Comments for Planning Application 2020/1381/FUL

Application Number: 2020/1381/FUL

Address: 15 Melton Road Langham Rutland LE15 7JN

Proposal: Replace 3 no. wooden windows with UPVC sash windows.

**SOUTH WEST ELEVATION**

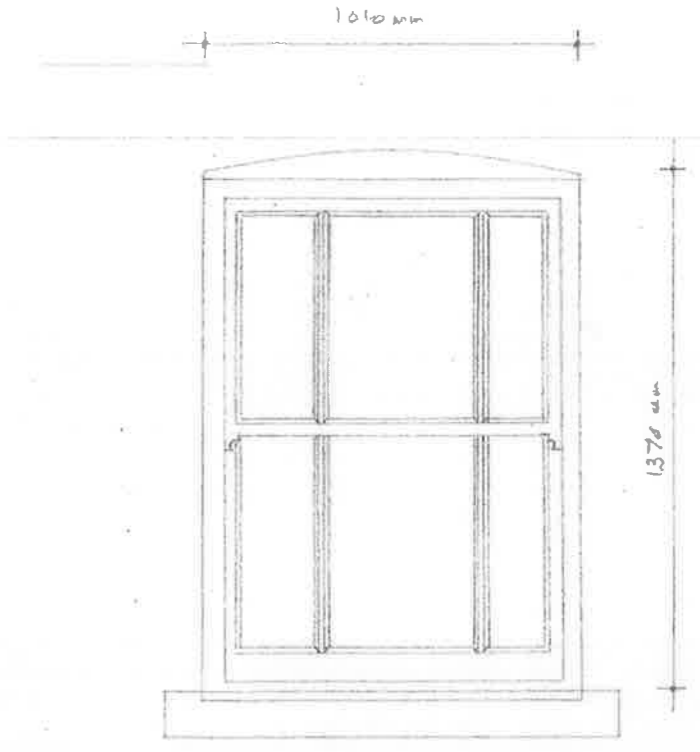
The applicant has taken care to replace the windows with exactly the same design as the existing ones and, as long as the lintels and sills are retained as they are, we would have no objections.
